From: Mark Warwick <Mark.Warwick@arun.gov.uk>

Subject: FW: AL/31/22/PL - Ryefields

Mark Warwick
Tree Officer, Environment and Climate Change

VISIBILITY SPLAYS AT ACCESS
2M X 23M AND 2M X 15M

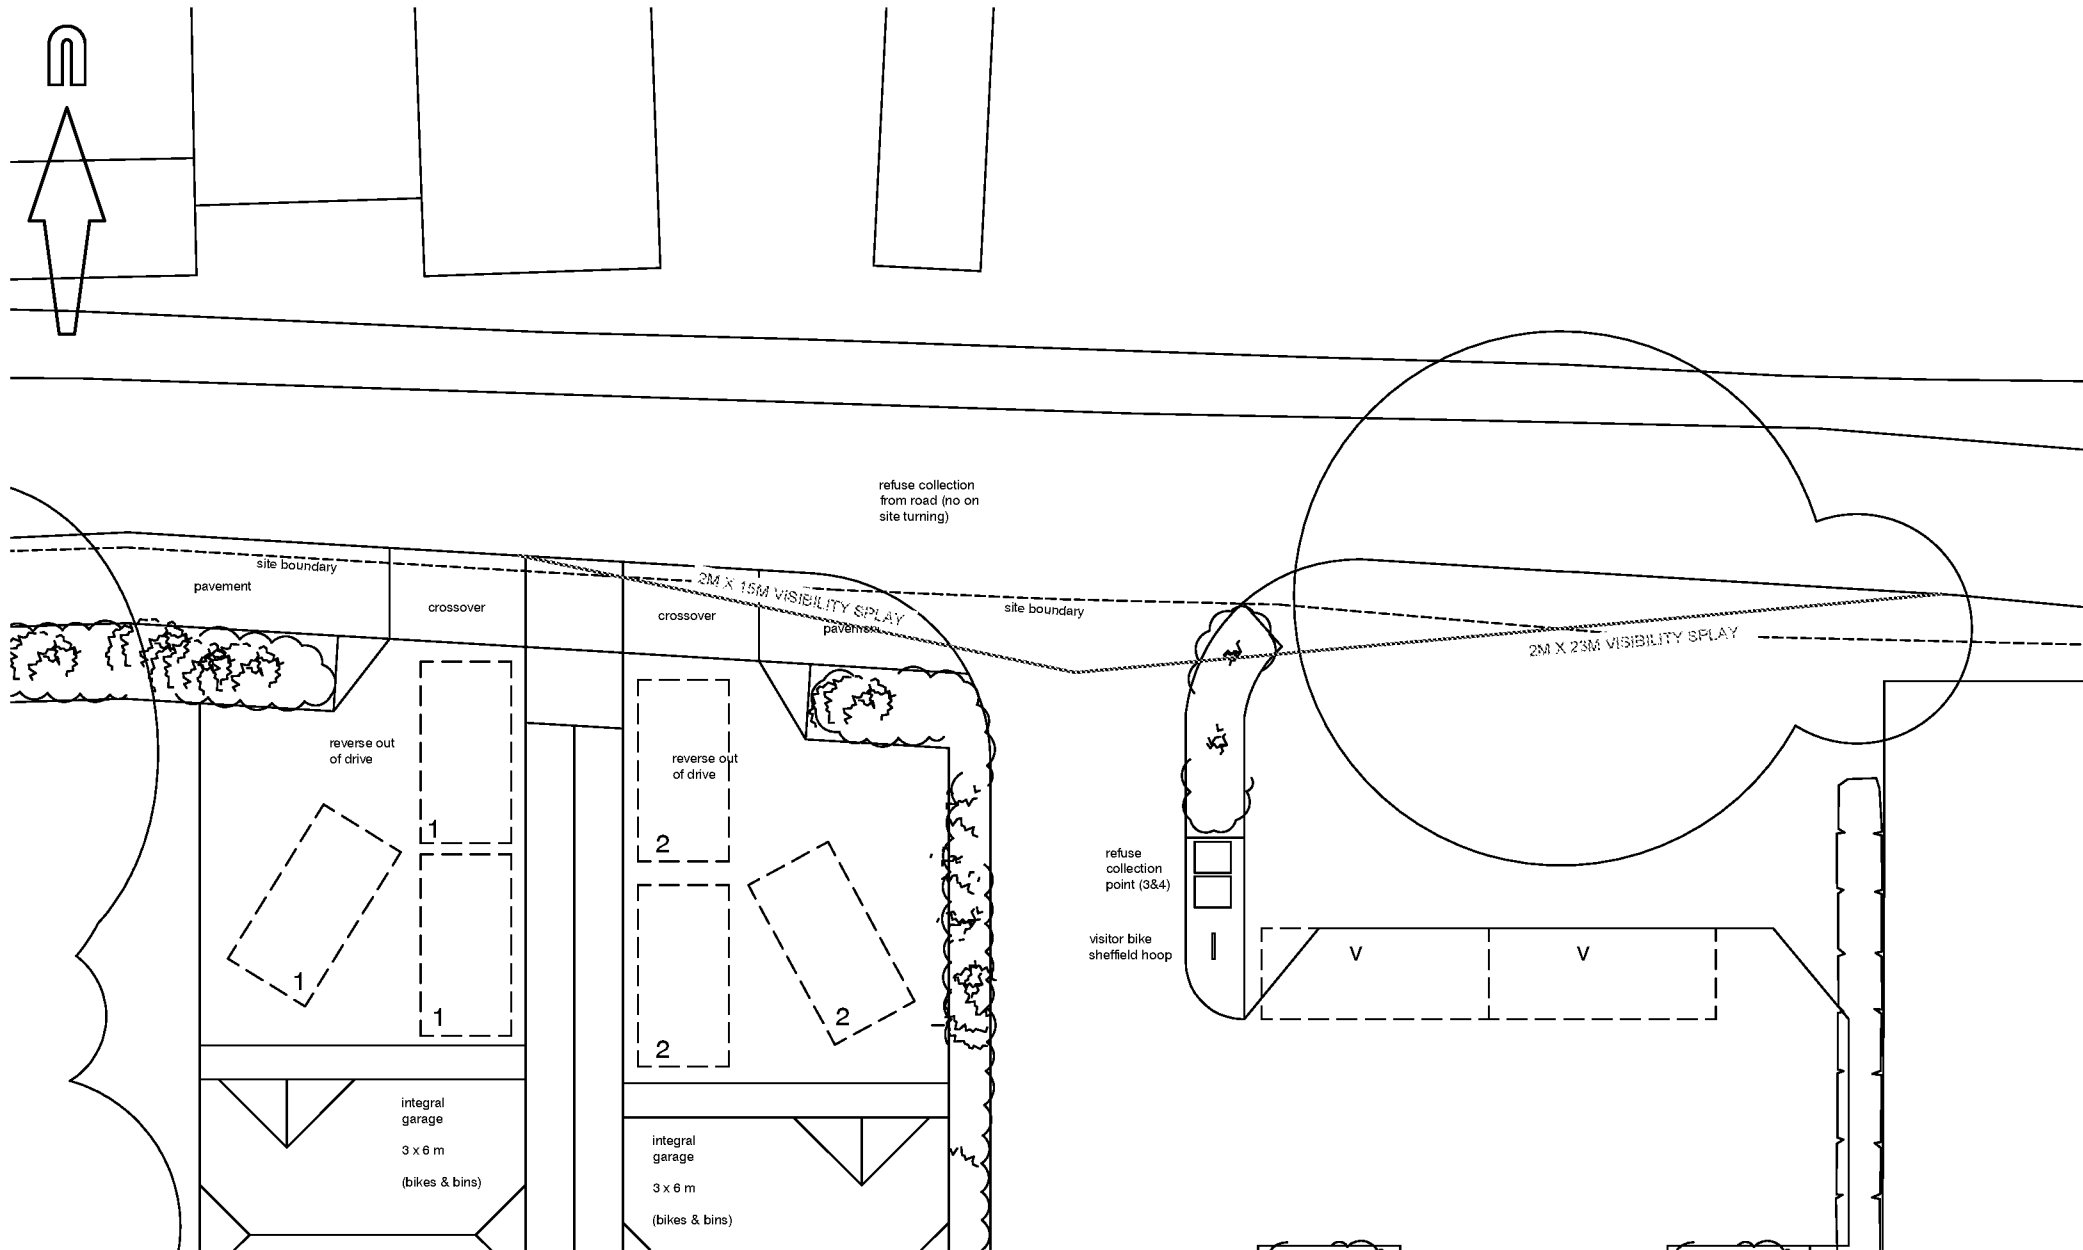
1. It looks like they have amended layout (shifted access west) and the vehicle sightline is no longer obstructed by the oak tree T15. That resolves the issue for me.

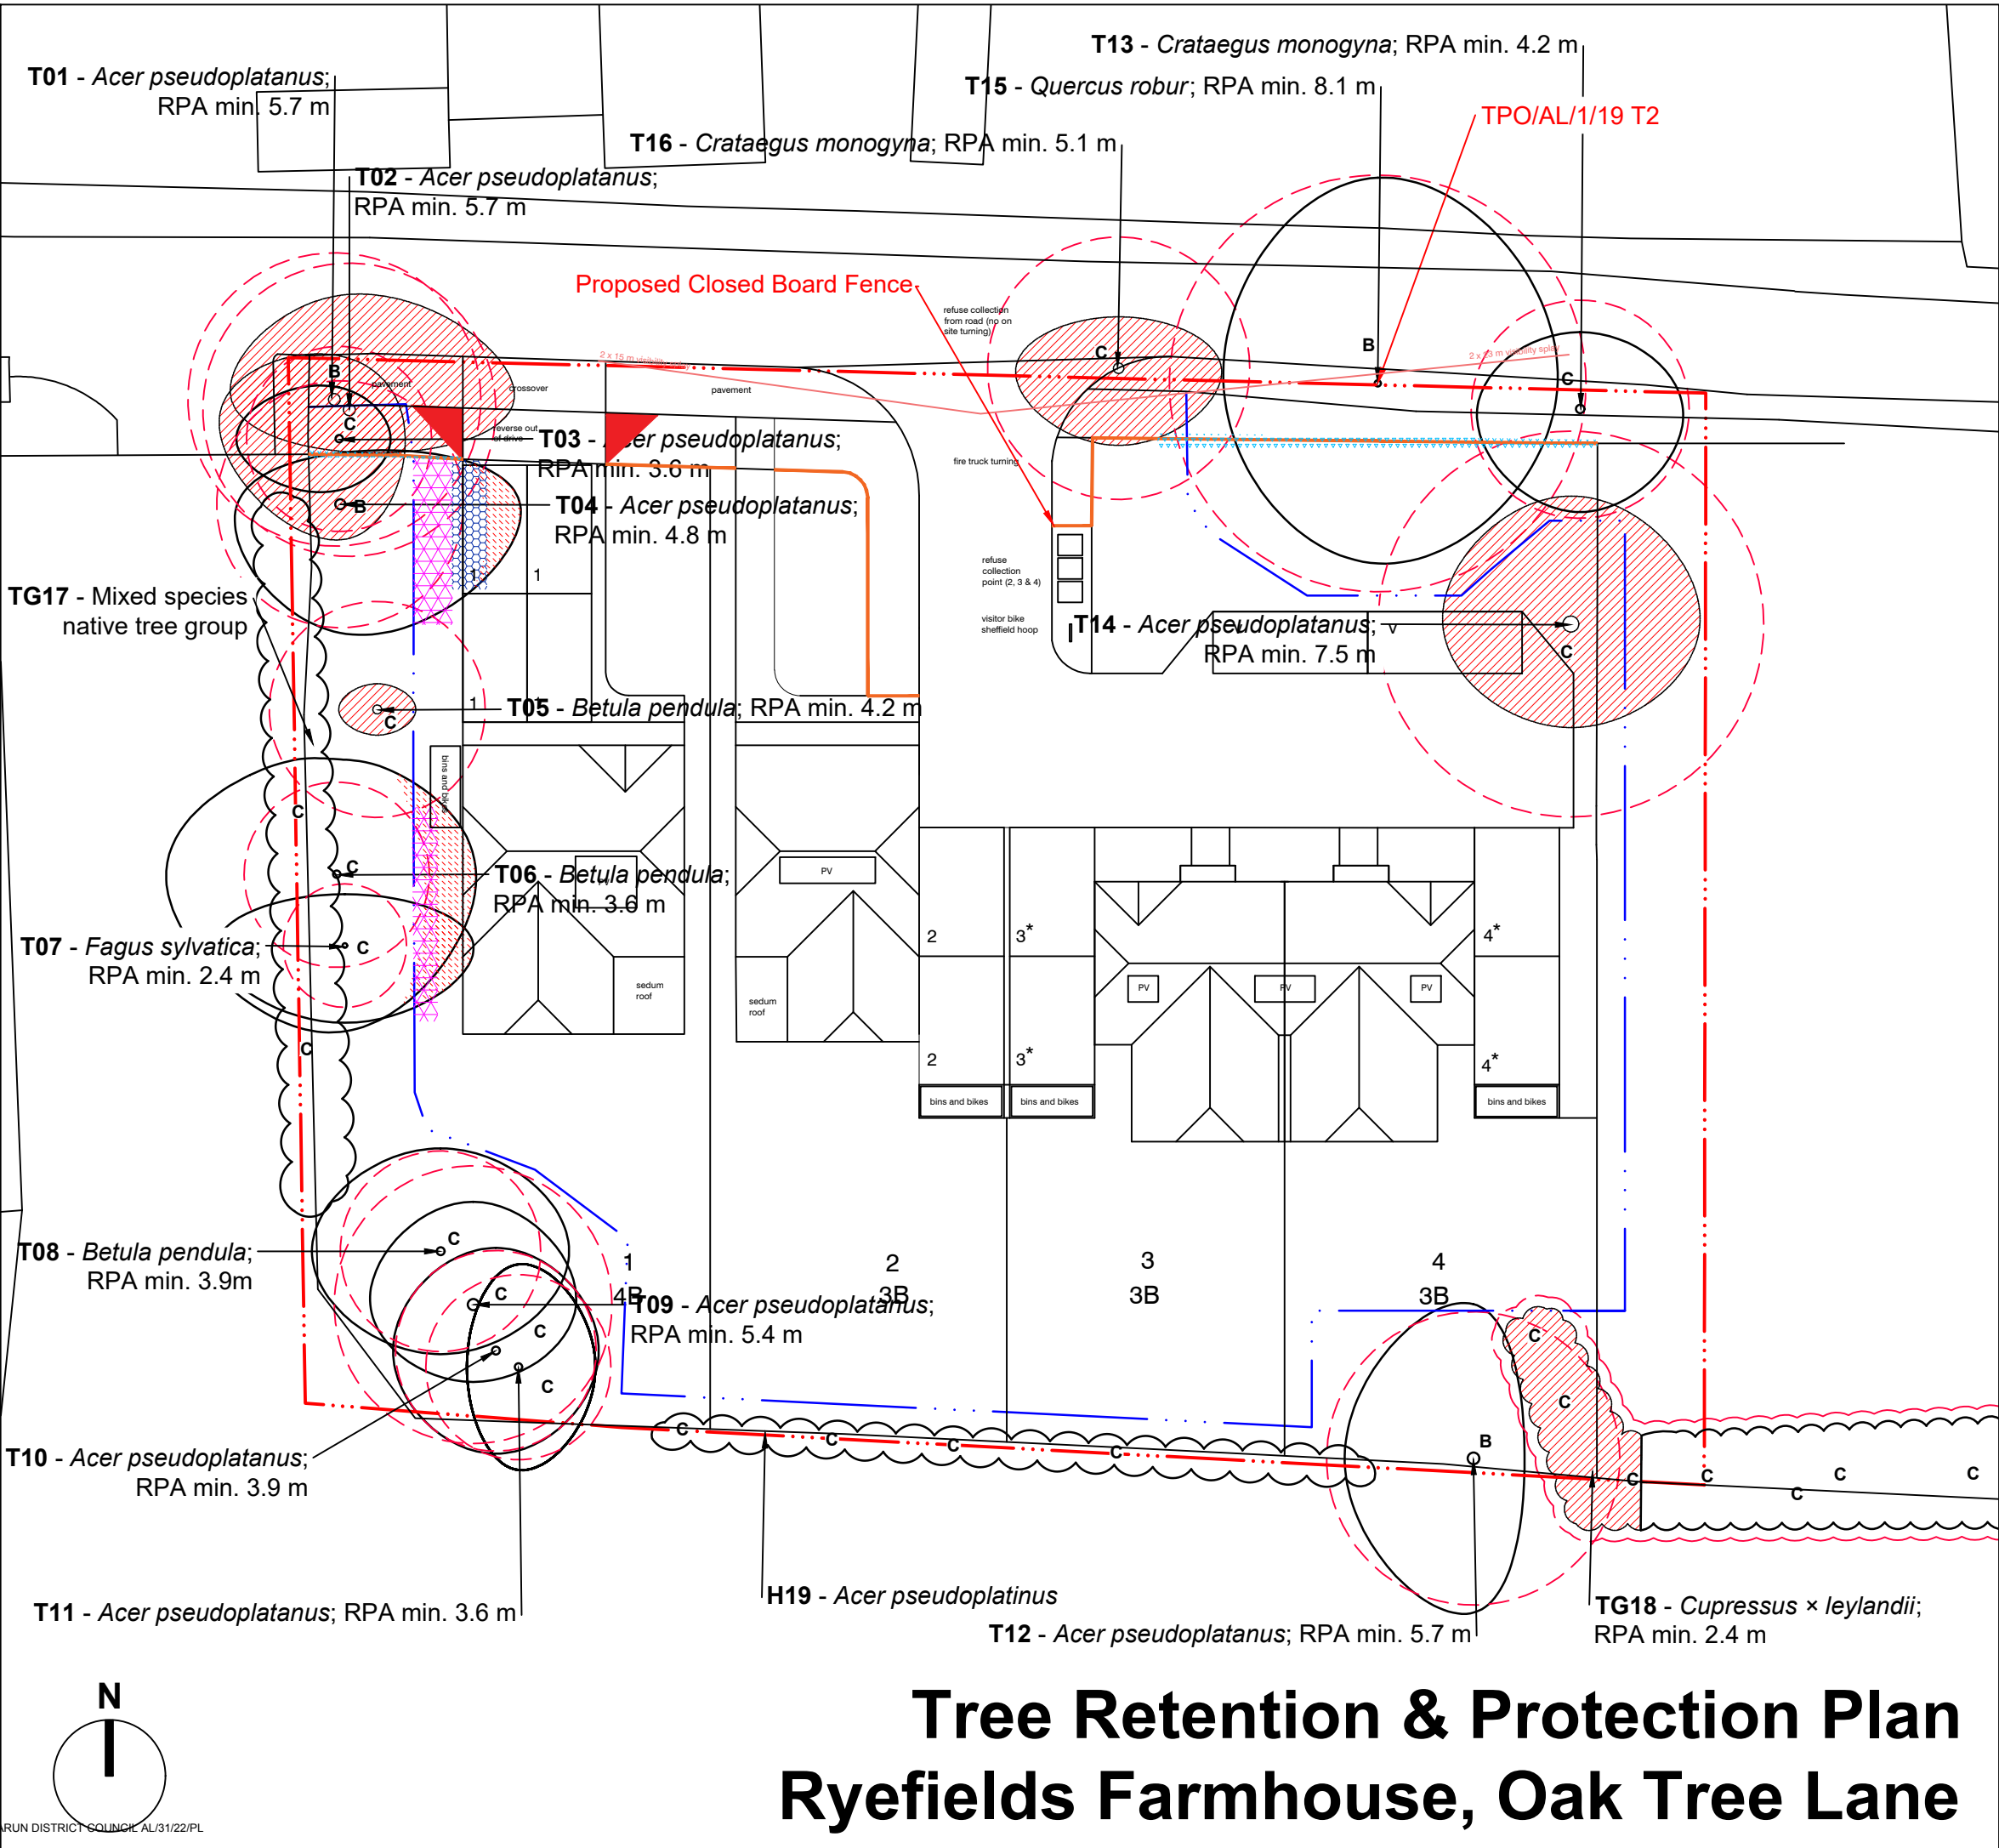
3. Surface water drainage strategy can be secured by condition. I probably cannot sustain an objection on those grounds alone.
4. The latest TRPP Rev 04 appears to show a proposed closed board fence bisecting the RPA of T15. It is vital that this work is initiated with exploratory trial holes to identify the optimum post-spacing to keep root damage to a minimum. Furthermore, only hand tools should be used to excavate and under arboricultural supervision. Those excavations should be lined with an impermeable membrane (e.g. polypropylene) to prevent curing cement being in contact with any roots. The supporting AIA&MS Rev 05 makes reference to the first two points (para. 2.11) but needs to include the latter instruction also.
